From: Nicola Moore on behalf of Planning.Responses
Sent: 13 November 2019 09:44
To: Planning Scanning
Subject: FW: A//55/19/PL

From: Roger Spencer [REDACTED]
Sent: 12 November 2019 15:56
To: Richard Smith [REDACTED]; Planning.Responses [REDACTED]
Cc: Raymond Cooper [REDACTED]; Robert Clark [REDACTED]
Subject: RE: A//55/19/PL

Can you help me on another matter, I am building a house in Angmering for my daughter Katie which has a pre commencement condition to have a surface water drainage scheme approved by your department before development is commenced.

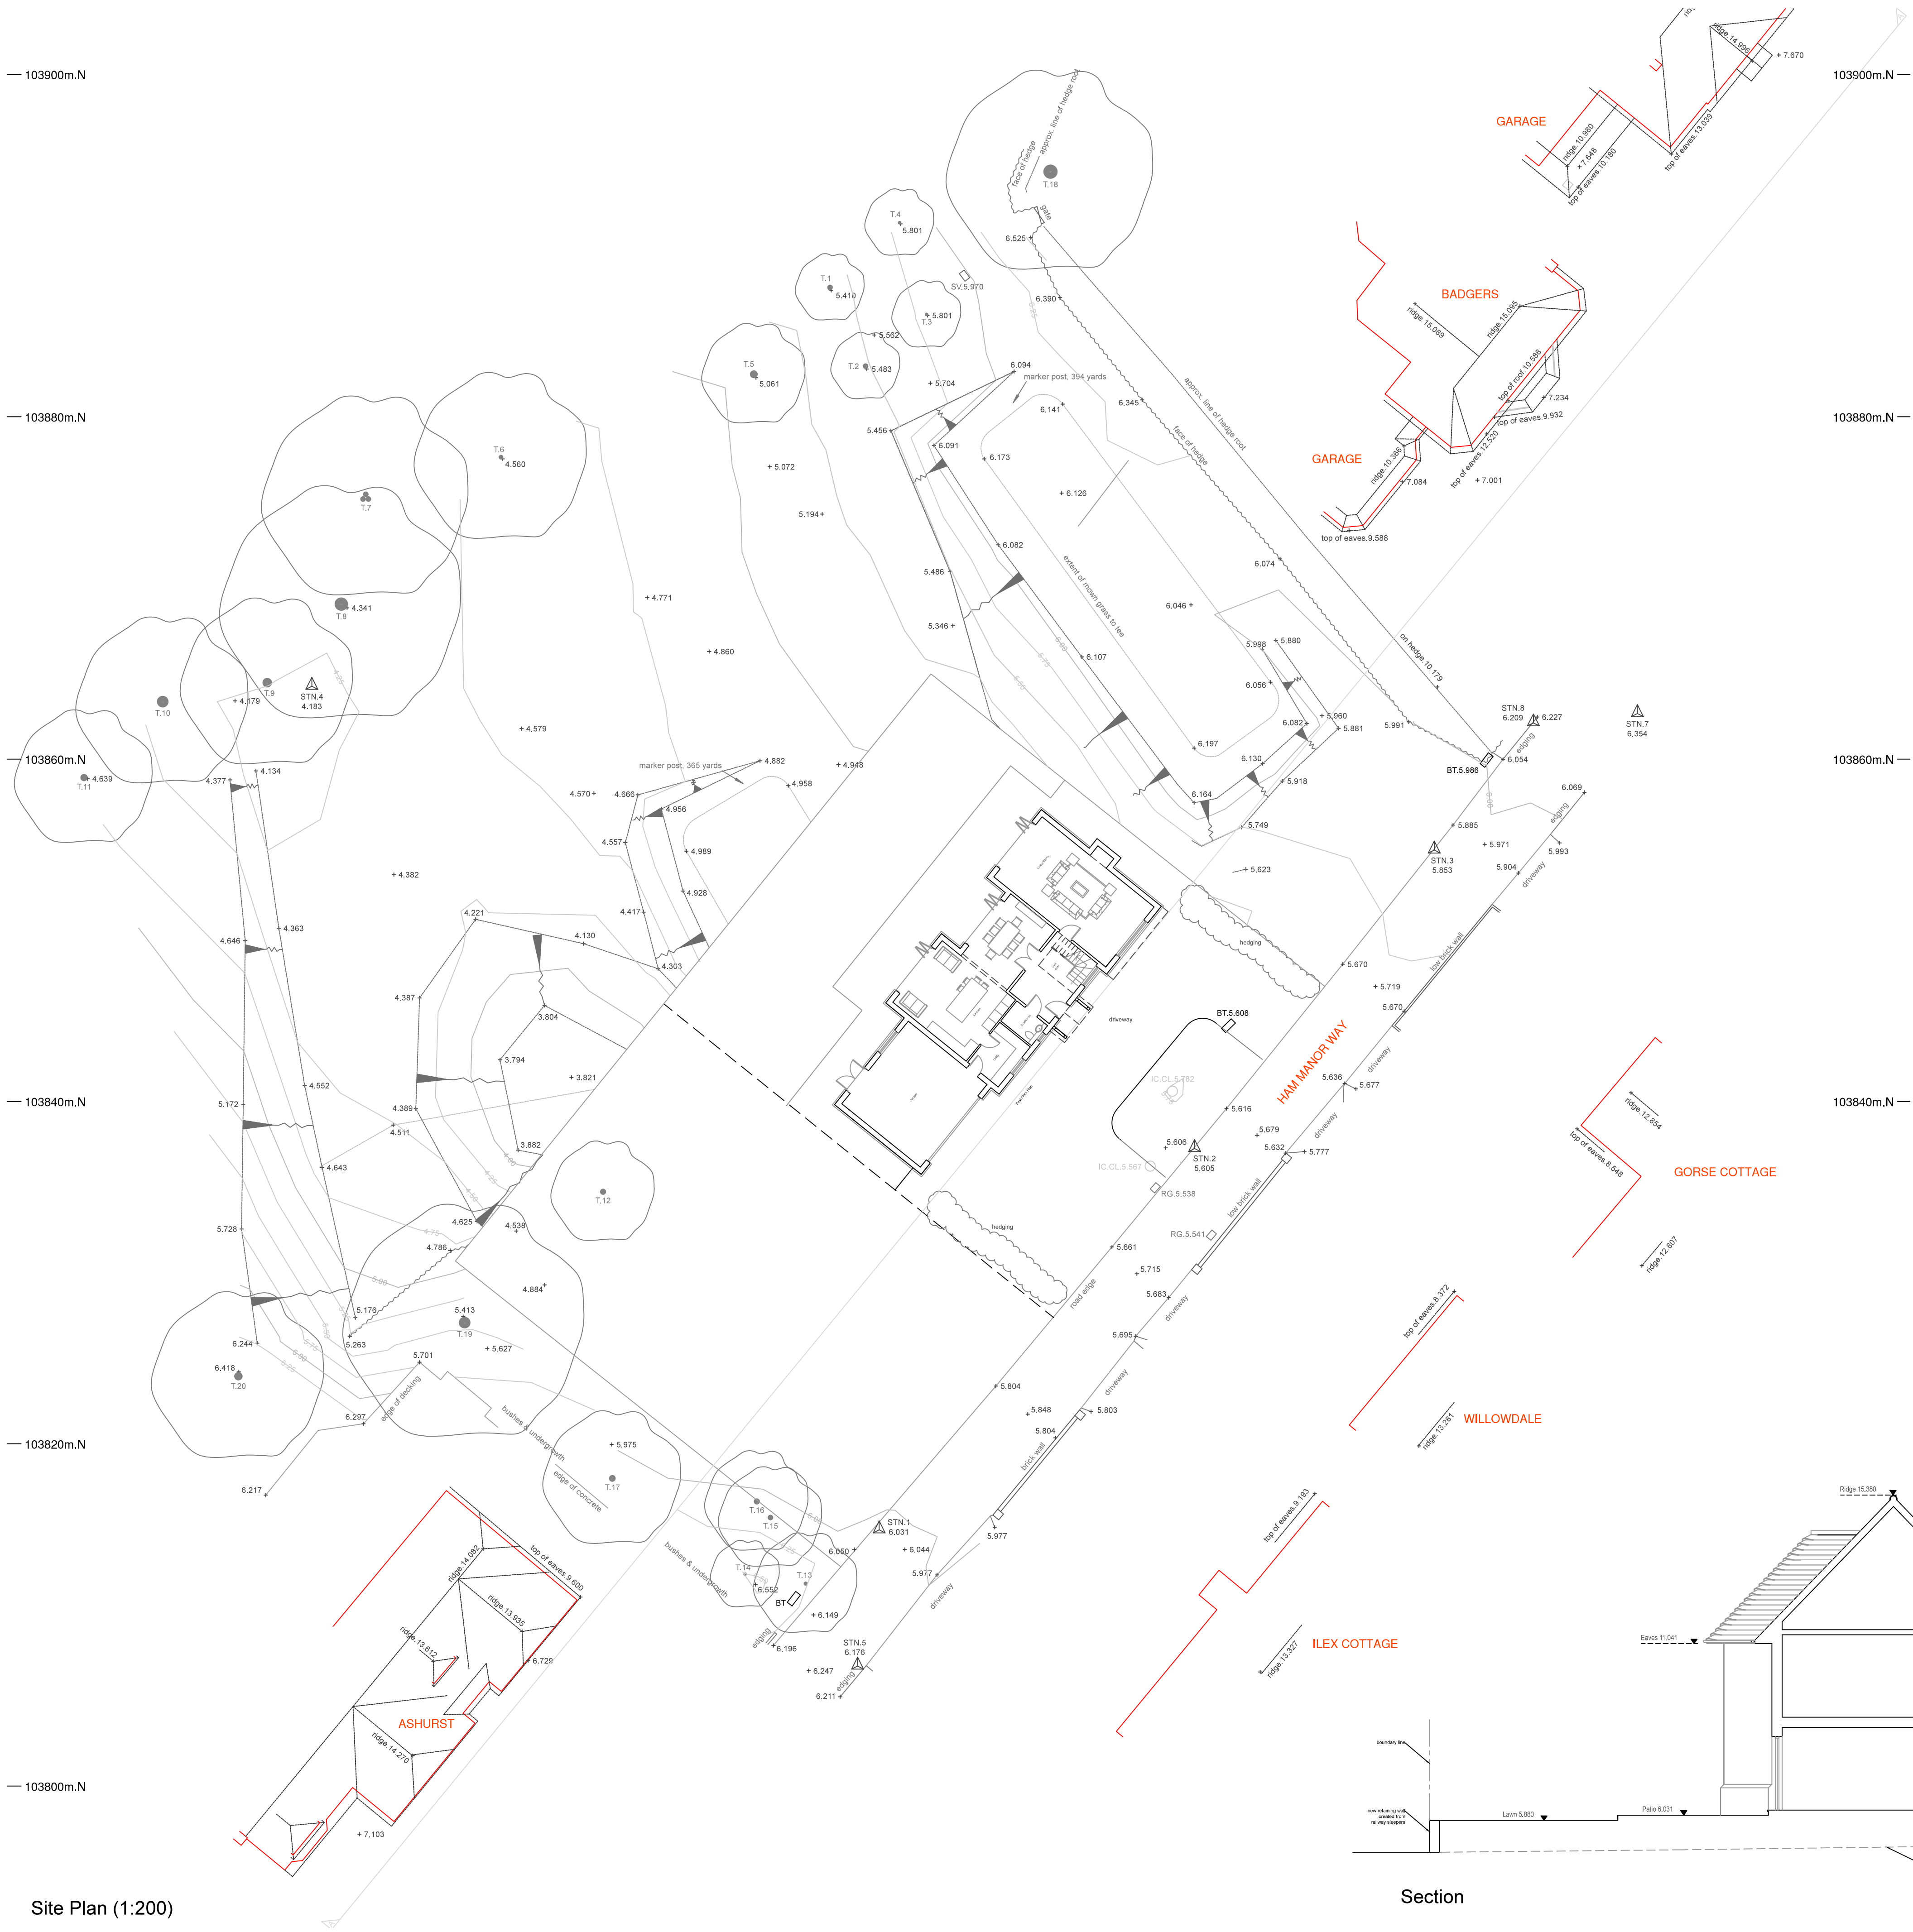
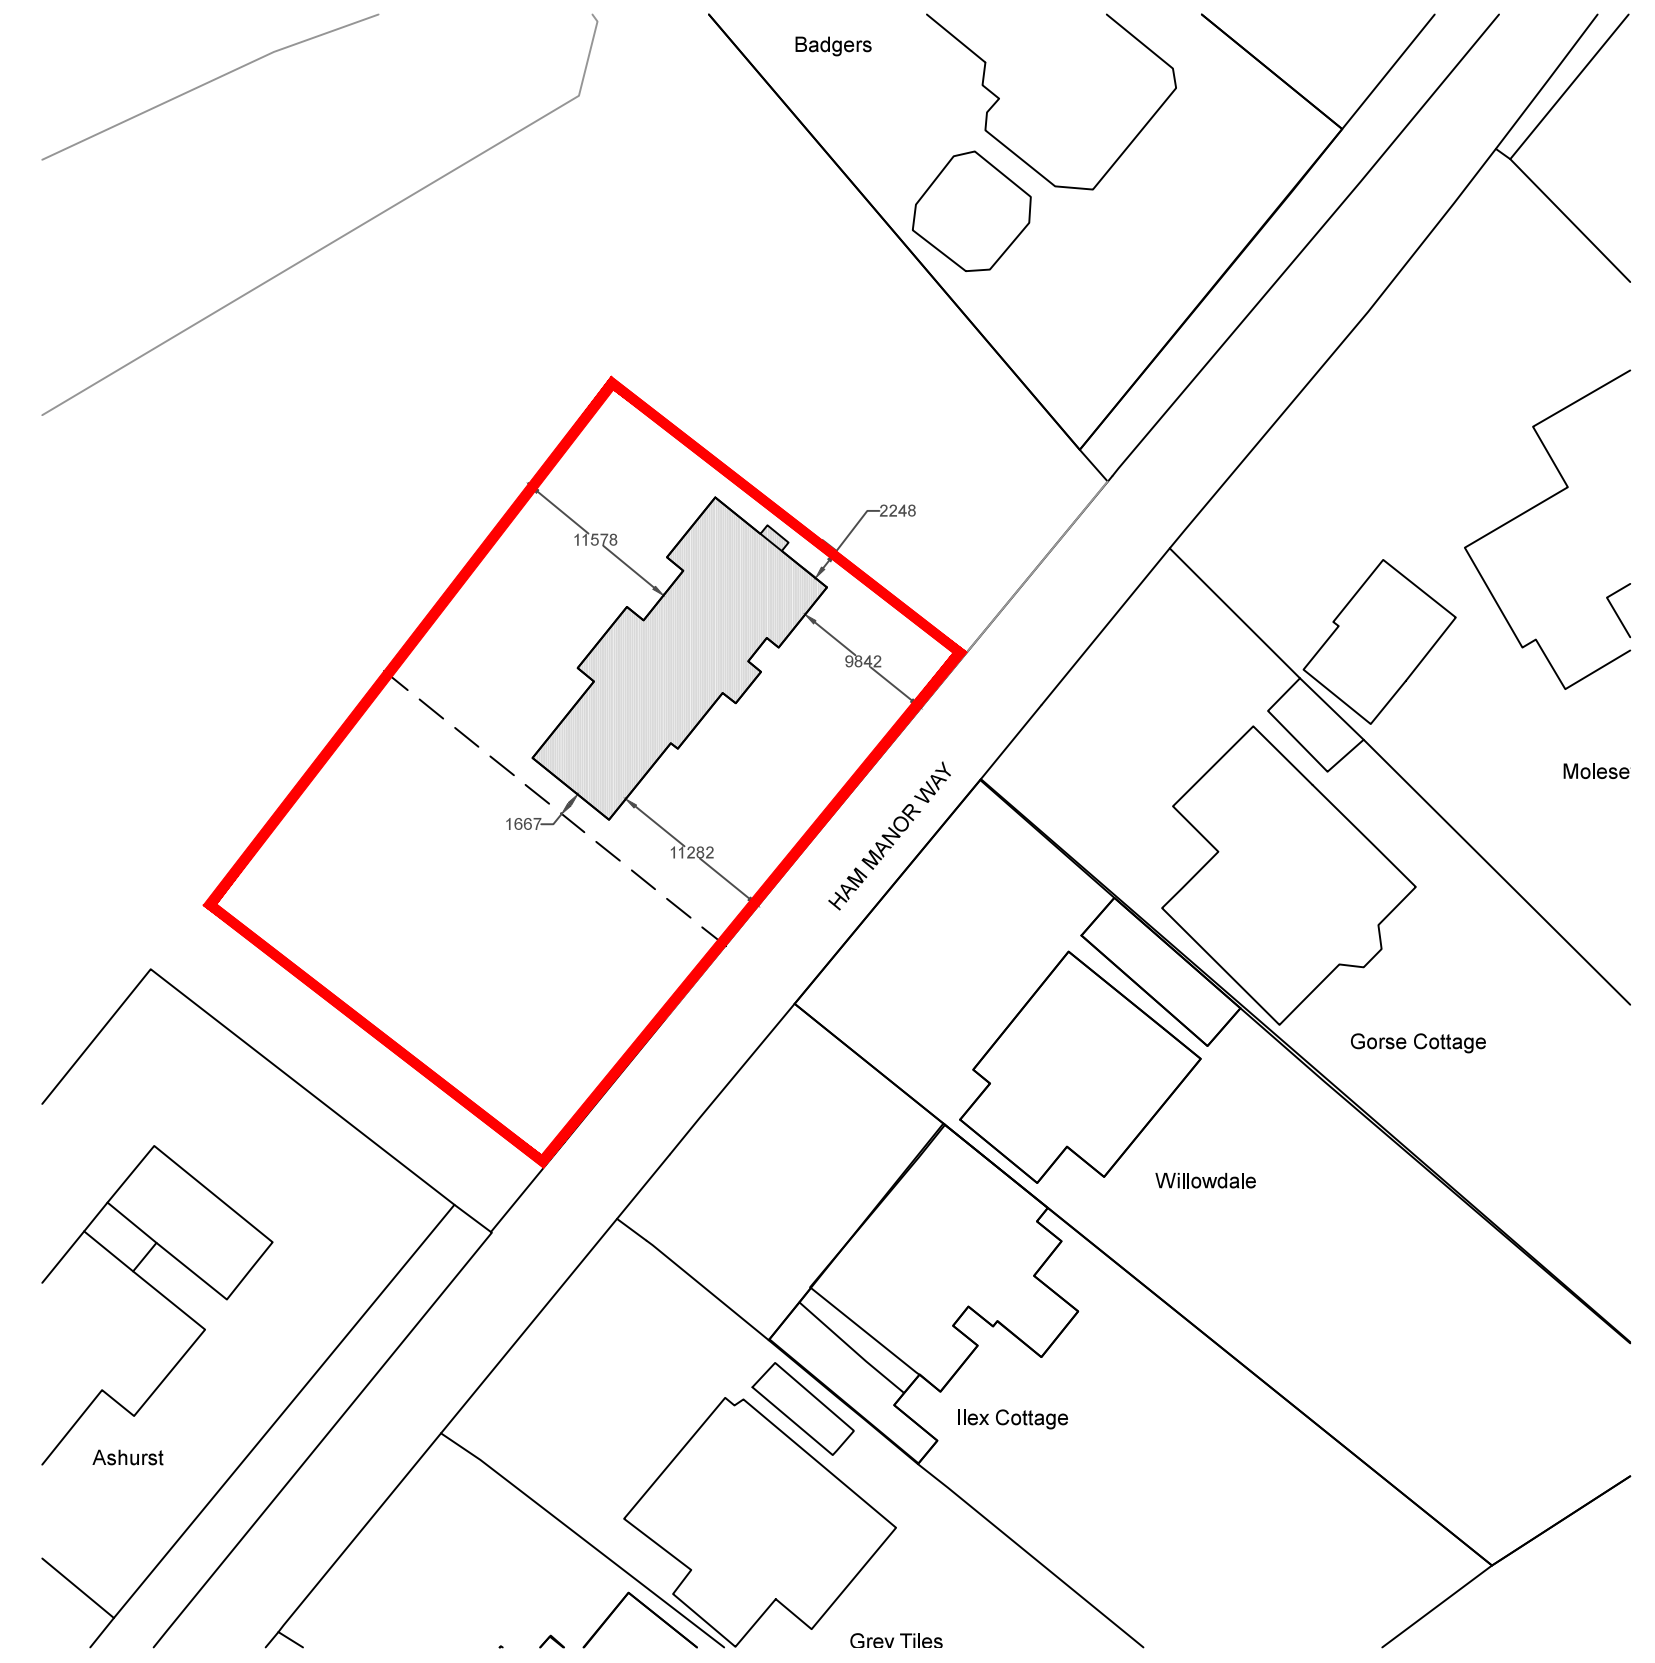
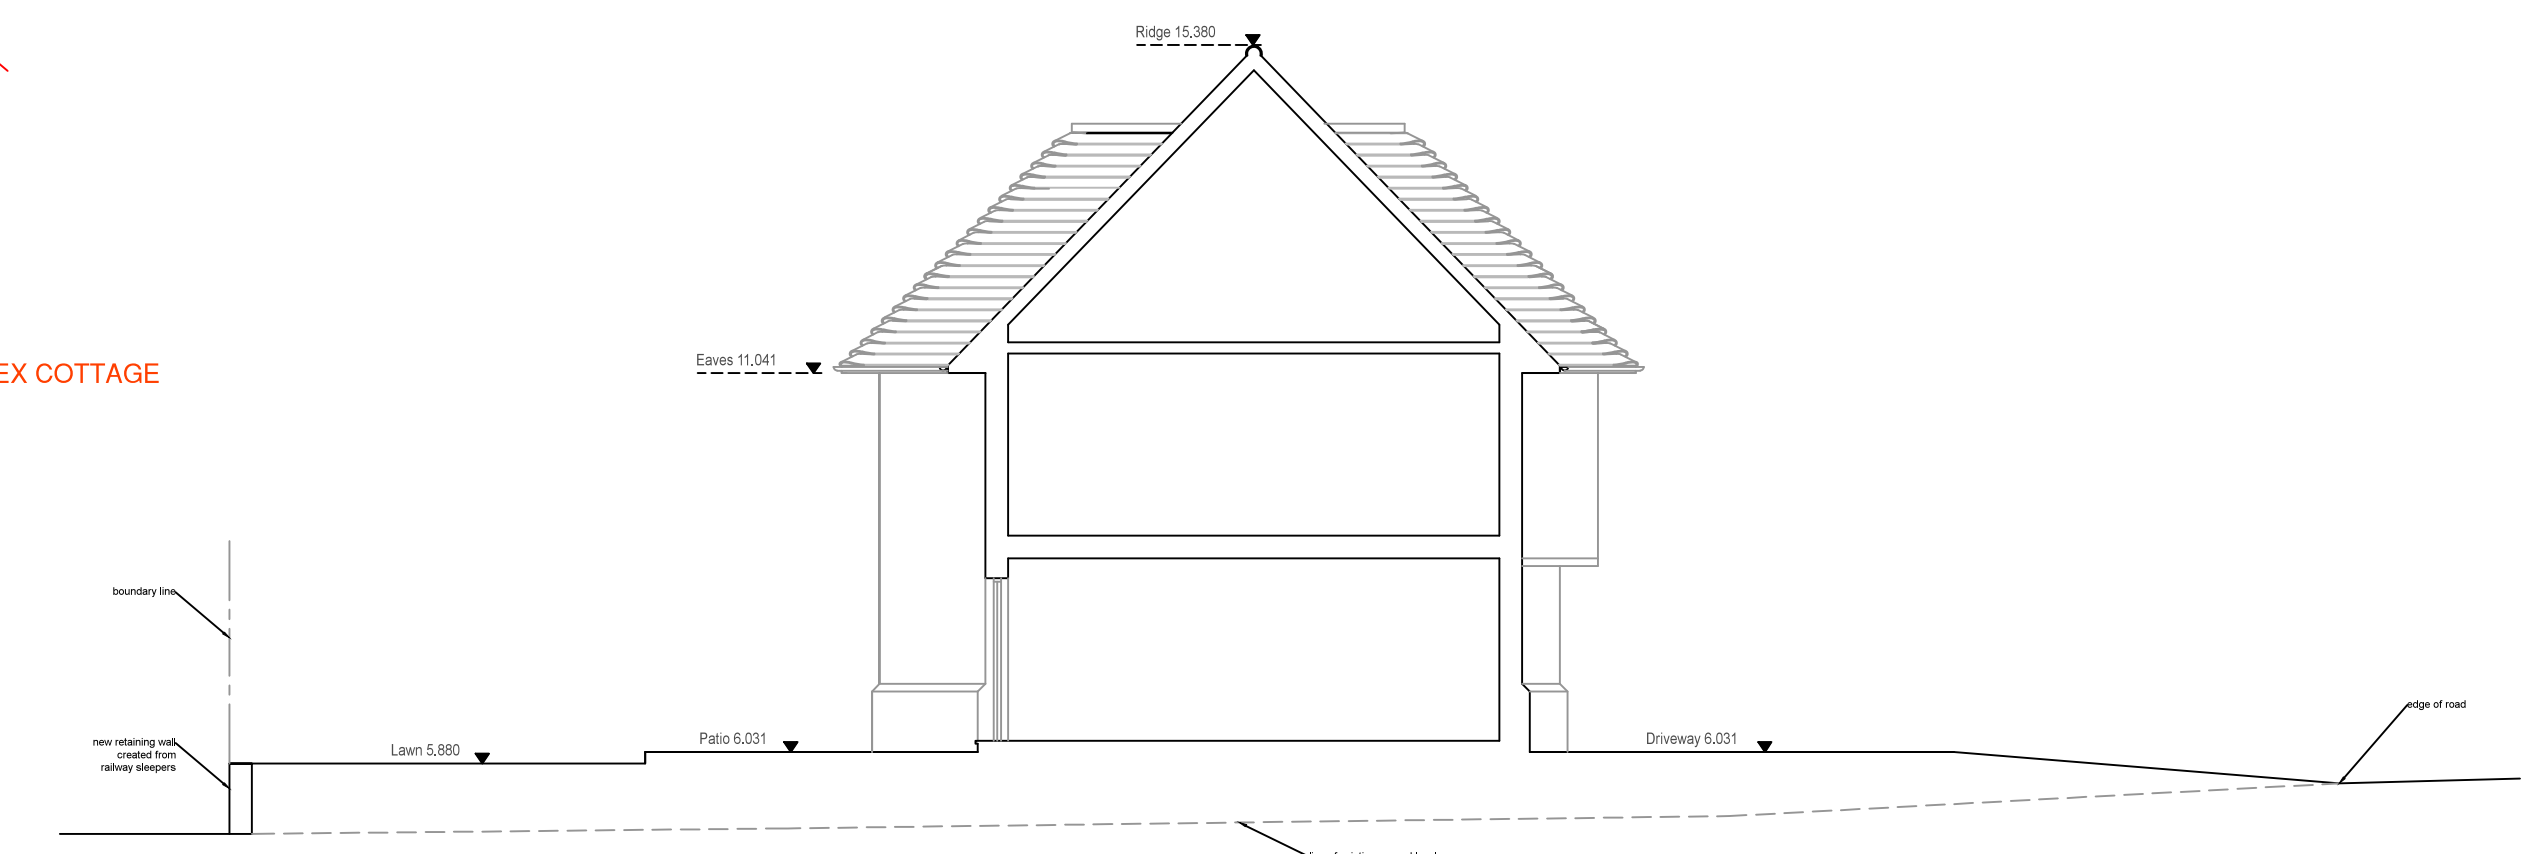
The condition was put on this application due to a specific surface water risk – the site is on a flow path from east to west – across Ham Manor Way towards Black Ditch, to the north-west. The 1in30 yr zone is within the 'red line' of the site but the 1 in 100 & 1 in 1000 zones are on the footprint of the building.

I note that you have March, September, October and November groundwater data. There has indeed been a lot of rain of late but it will take some time for that water to get into the system. I would like to see monitoring continue through to January when we would expect to see a peak in groundwater levels.

It is important to assess the groundwater levels, as this will guide further assessment (infiltration) that will then inform the disposal method/route (inc. the existing risk), so it fundamental to get this bit right. Robert Clark Associates are well versed in this process.
